August 5, 2020

**RE: Sonta Trails Unit 4 Apartments
Conceptual Grading & Drainage Plan and Drainage Report
Engineer's Stamp Date: 07/20/20
Hydrology File: C10D001A**

Based upon the information provided in your submittal received 07/22/2020, the Conceptual Grading & Drainage Plan and Drainage Report **are not** approved for action by the DRB on Site Plan for Building Permit and Site Plan for Subdivision. The following comments need to be addressed for approval of the above referenced project:

EXHIBIT 2 PROPOSED BASINS

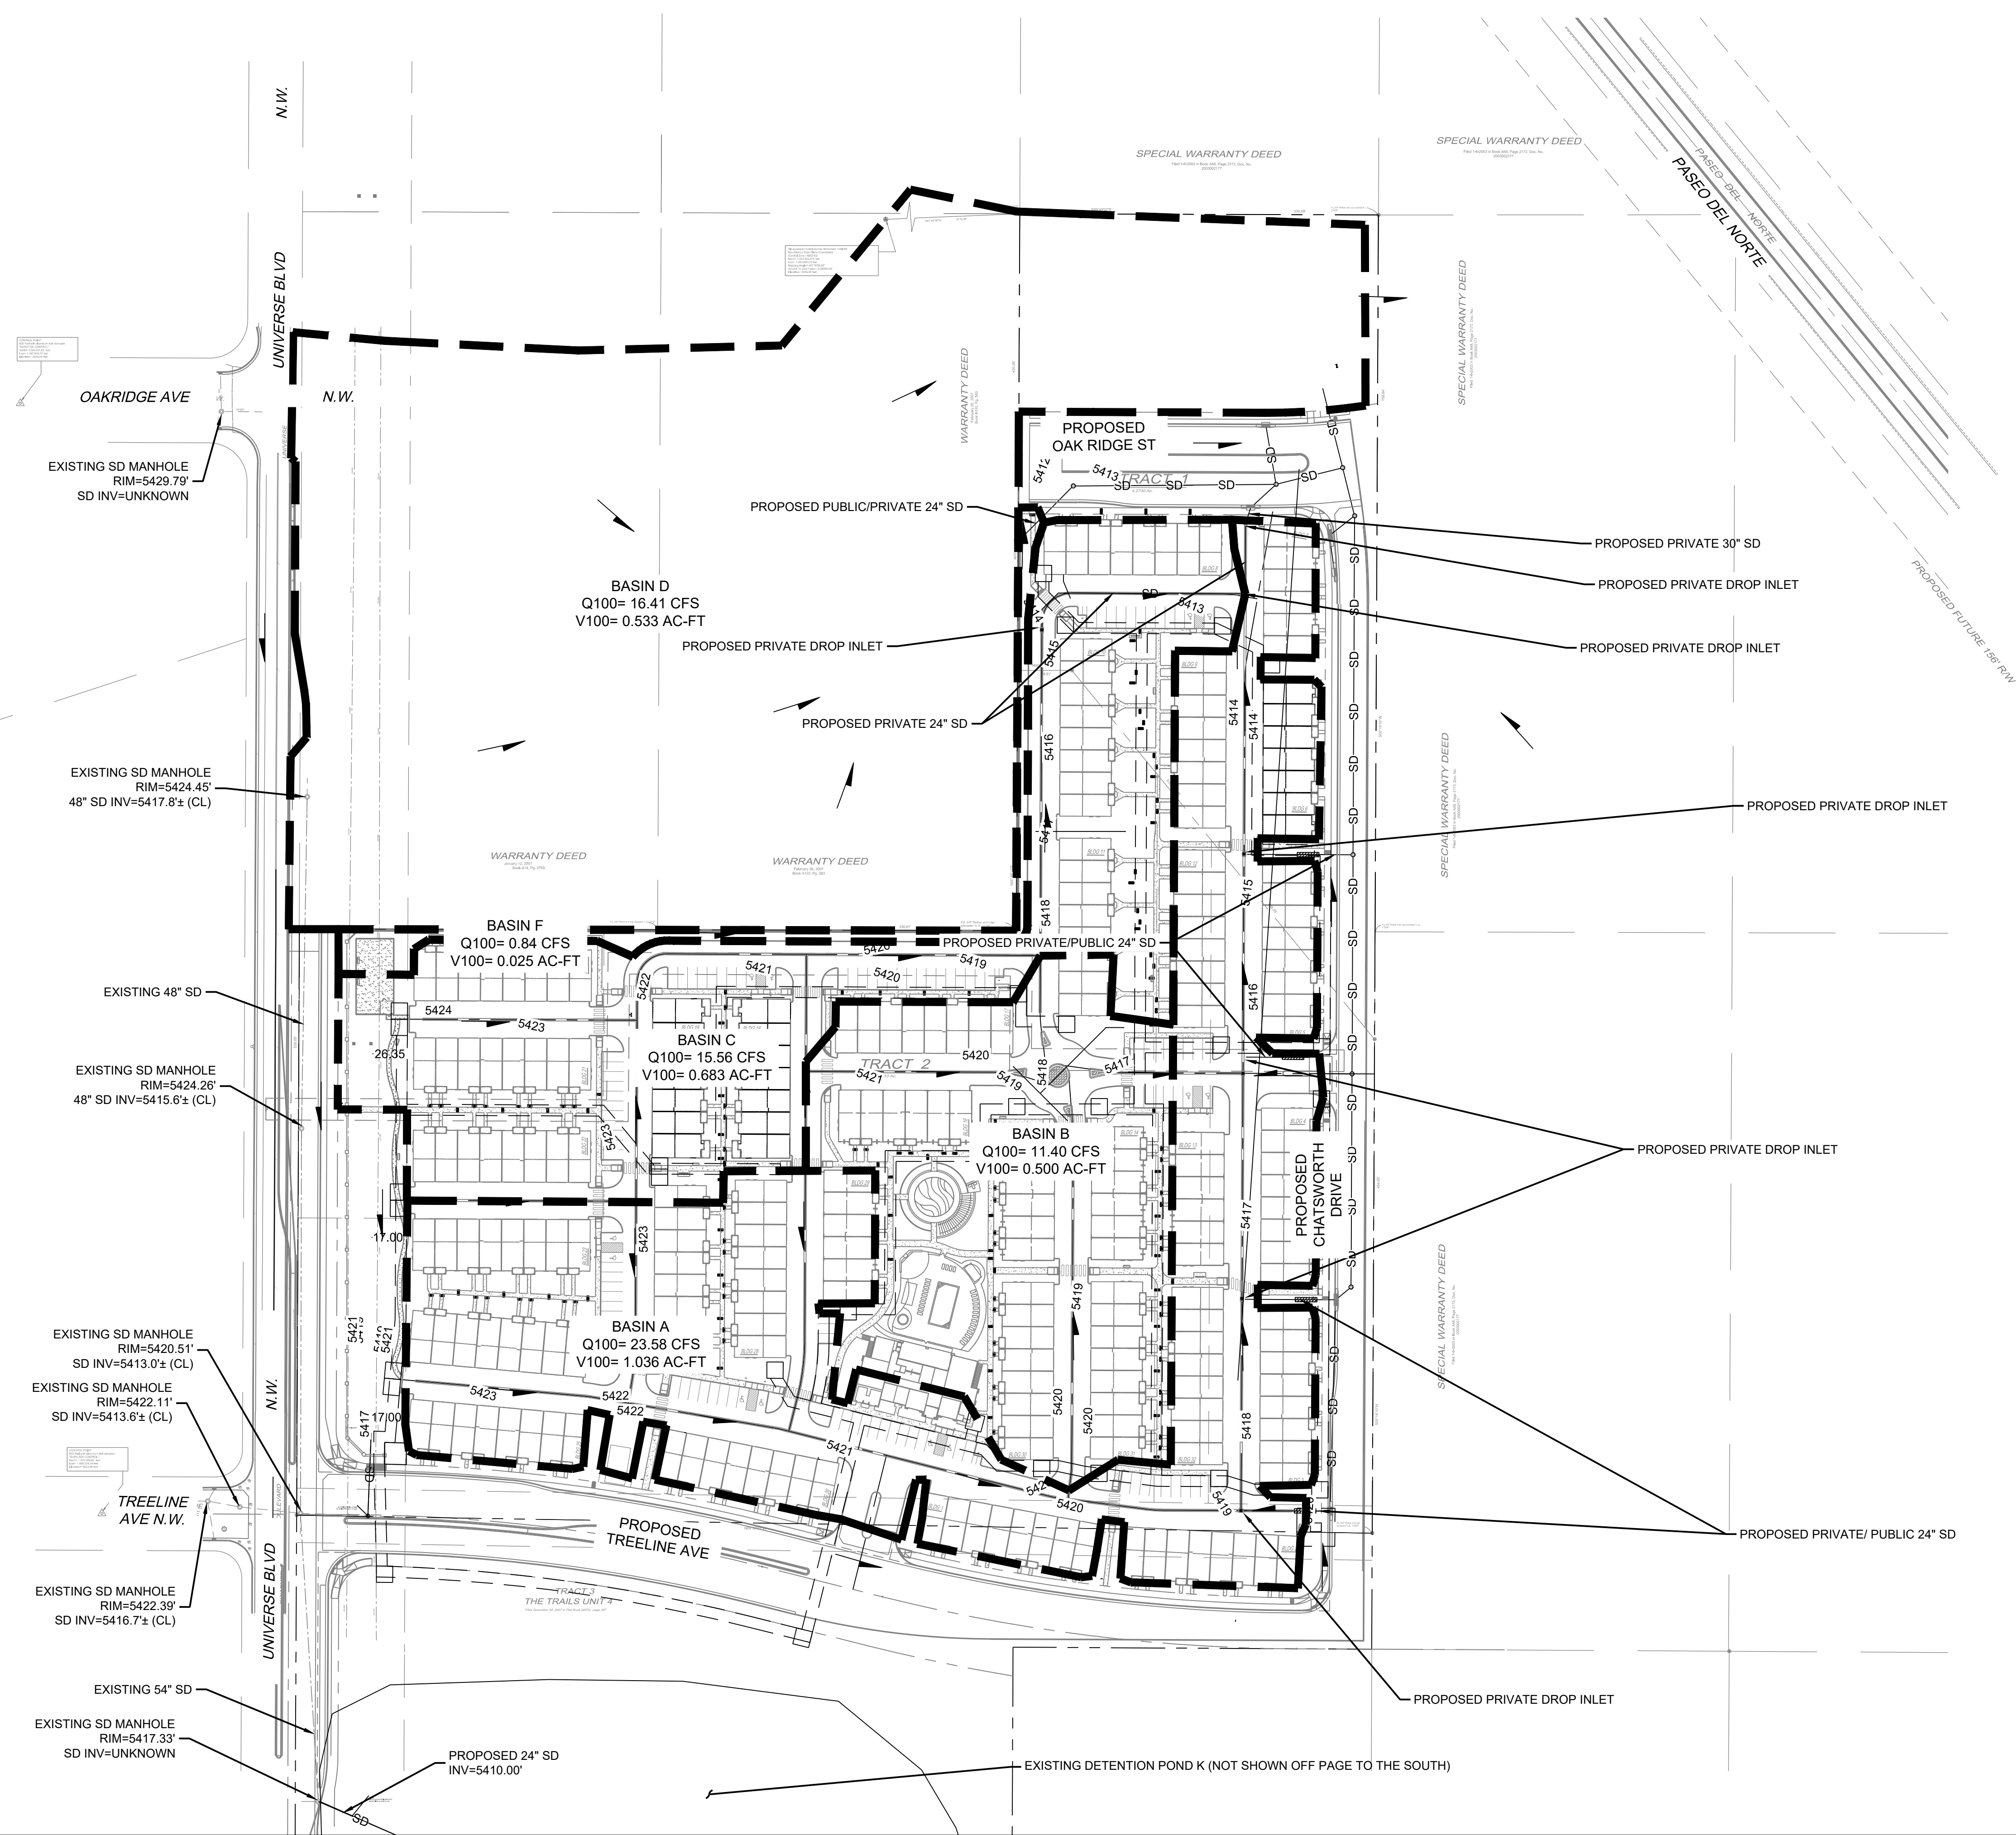
1. Exhibit 2. Please just provide the Private Development in this Exhibit. All the public R.O.W. and Ponds (J, K, & A) will be in Exhibit 3.

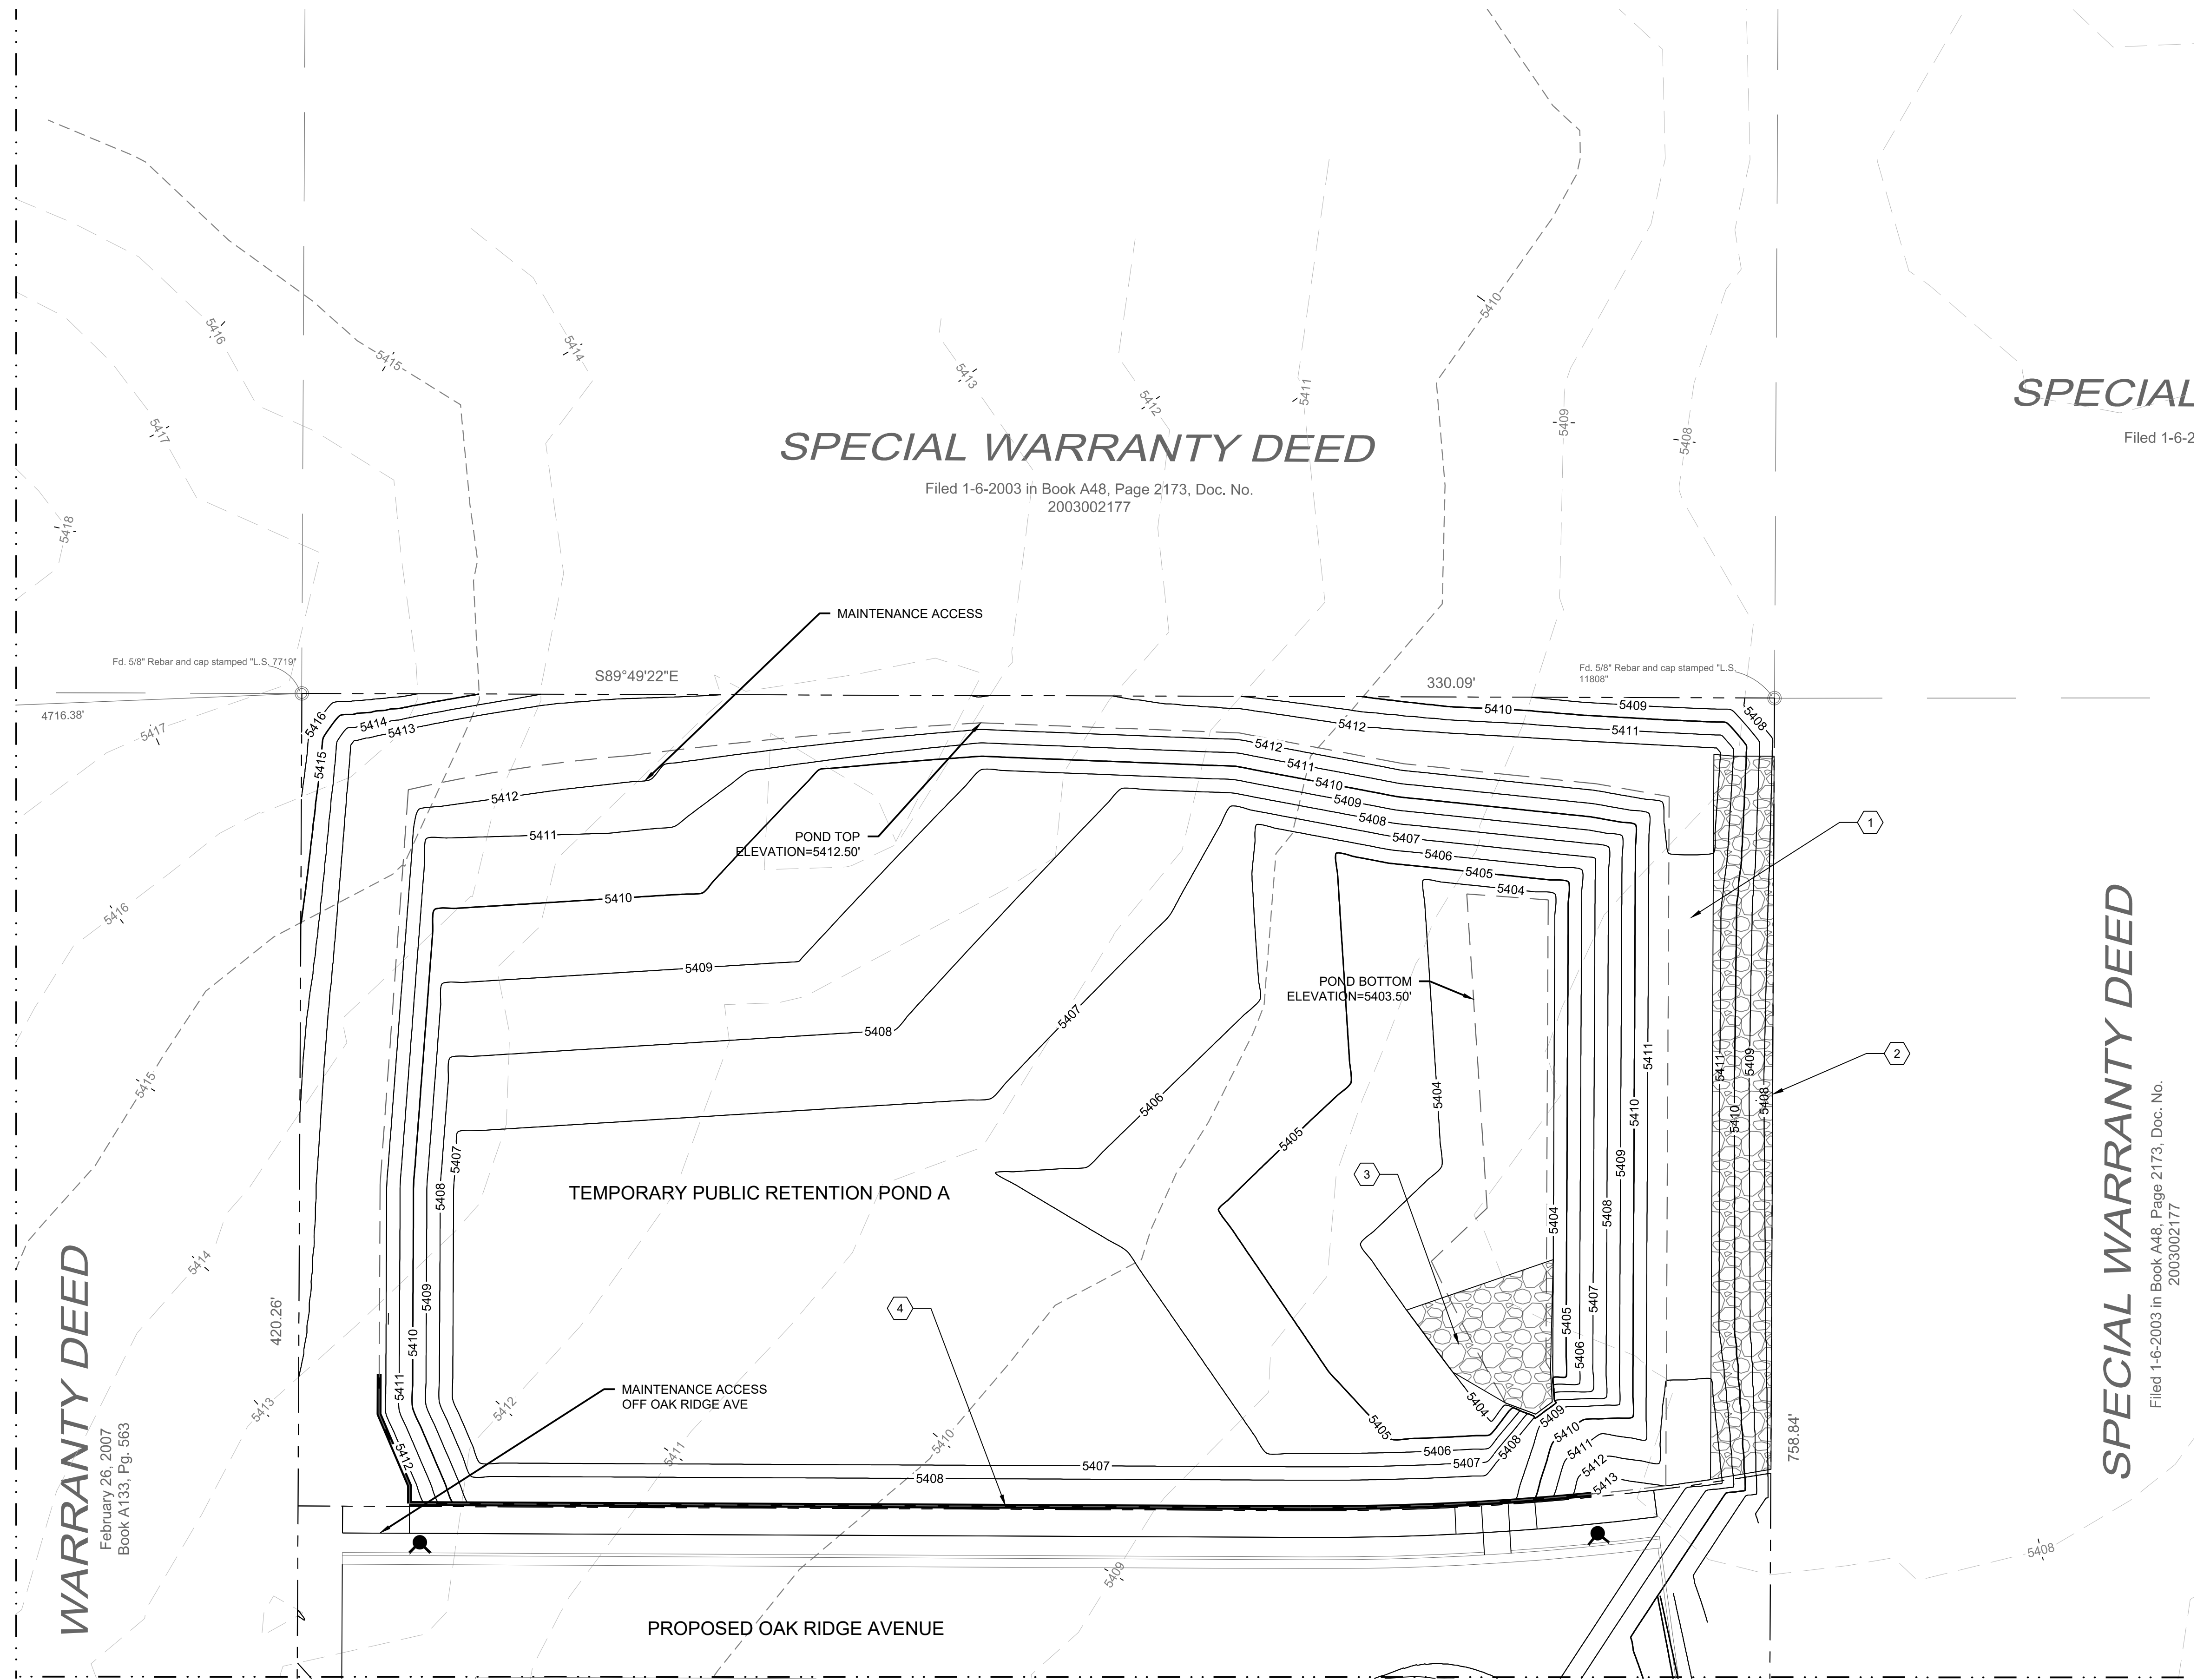
2. Exhibit 3. Comments are too numerous to be noted here. Please see attached plan with redlines. Re-evaluation of all the drainage areas and the proposed infrastructure needs to be done. Please call to discuss.

EXHIBIT 4 TEMPORARY PUBLIC
RETENTION POND A

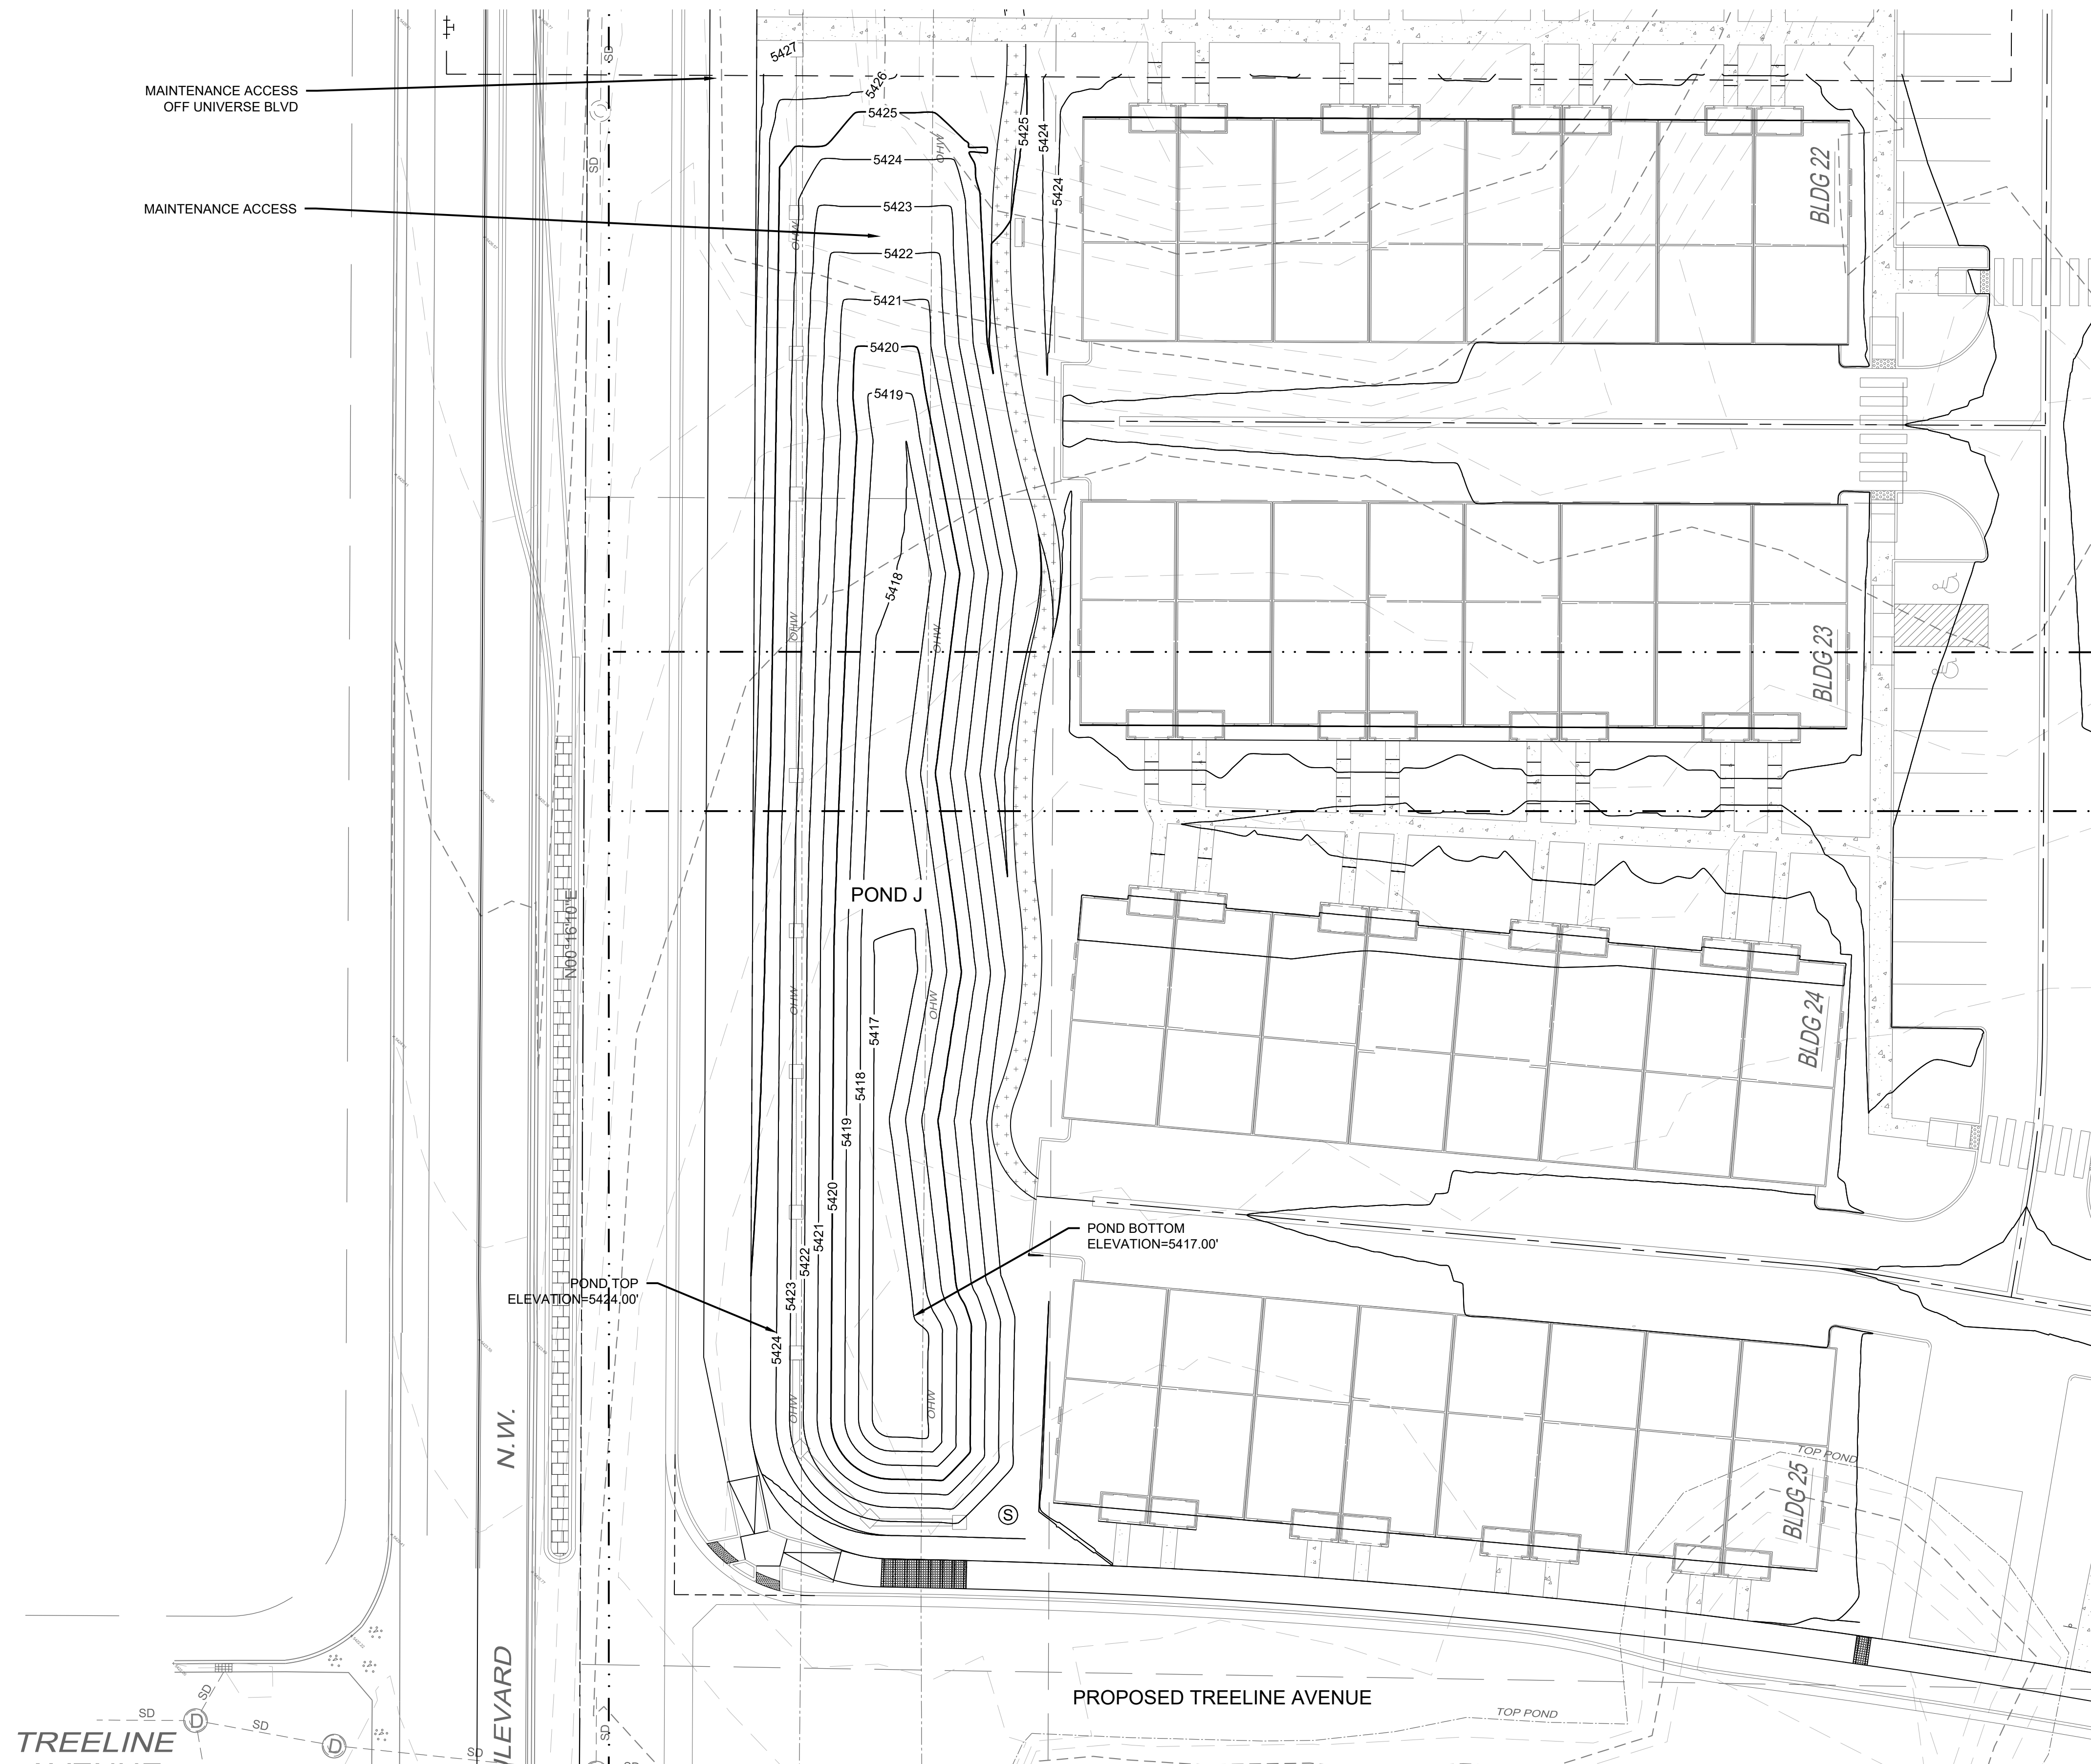
3. Pond A. This pond will not be a detention pond. It must be a Temporary Retention Pond with the volume for 100 year – 10 day since there is no downstream infrastructure built for the pond's watershed. There will be an Ultimate Pond area for the entire drainage area that will be discharged into it and Phase 1 pond which will be just what is going to be constructed at this time. You can then show the Phase 1 pond area for all of the areas are going to be built with the private development. This Phase 1 pond will be shown on Exhibit 2 whereas the Ultimate Pond area will be shown on Exhibit 3.
